## M3 Junction 9 Improvement Scheme

### Deadline 4

#### Hampshire County Council comments on the Statement of Common Ground with Cycle Winchester dated 31 July 2023 (Examination document AS-009).

DRAWING TITLE
**GENERAL ARRANGEMENT PLANS
 APPP REGULATION 5(2)(c)
 SHEET 3 OF 10
 DOCUMENT REFERENCE: 2.5**

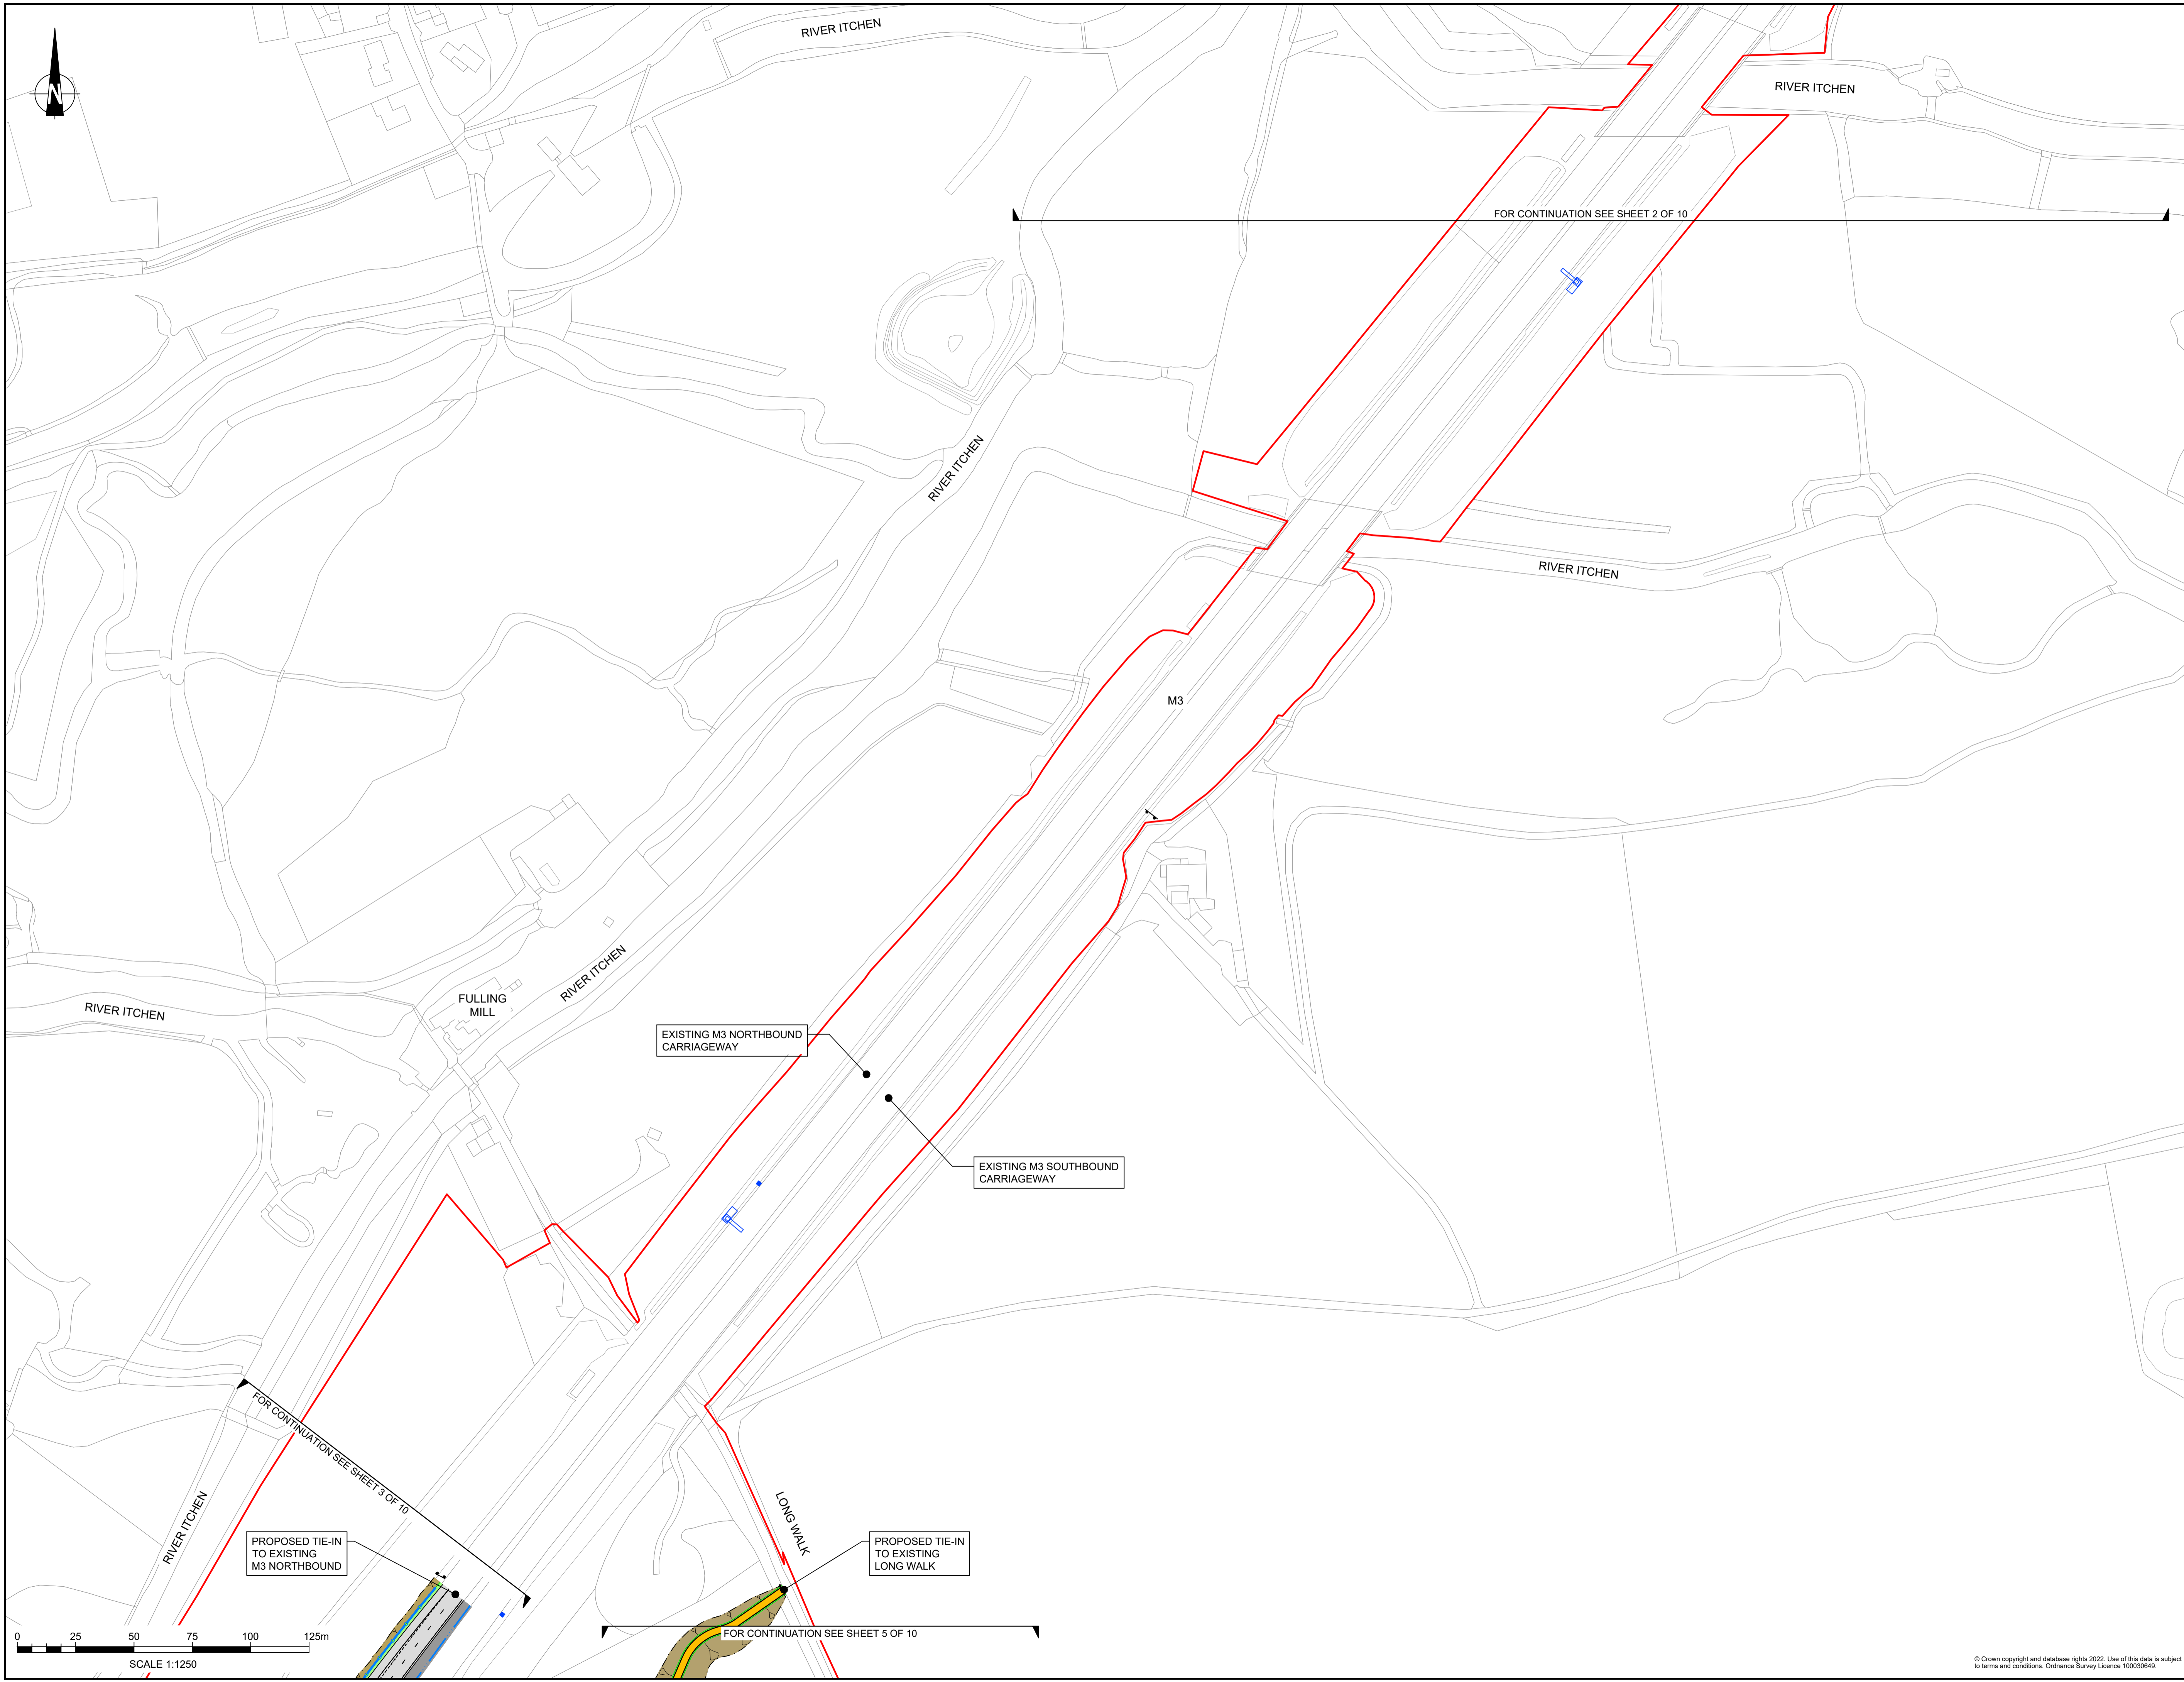
4.6	Sheet 3 of General Arrangement Plans (2.4, APP-009)	The County Council has stated its position on the Cart and Horses junction.
4.8	Typical Carriageway Sections of Engineering Plans and Sections (2.6, Rev 1)	The County Council consider the new BW will be of the width required in the Hampshire Countryside Service Design Standards (3m for a BW). There will be no fencing enclosing the PROW.
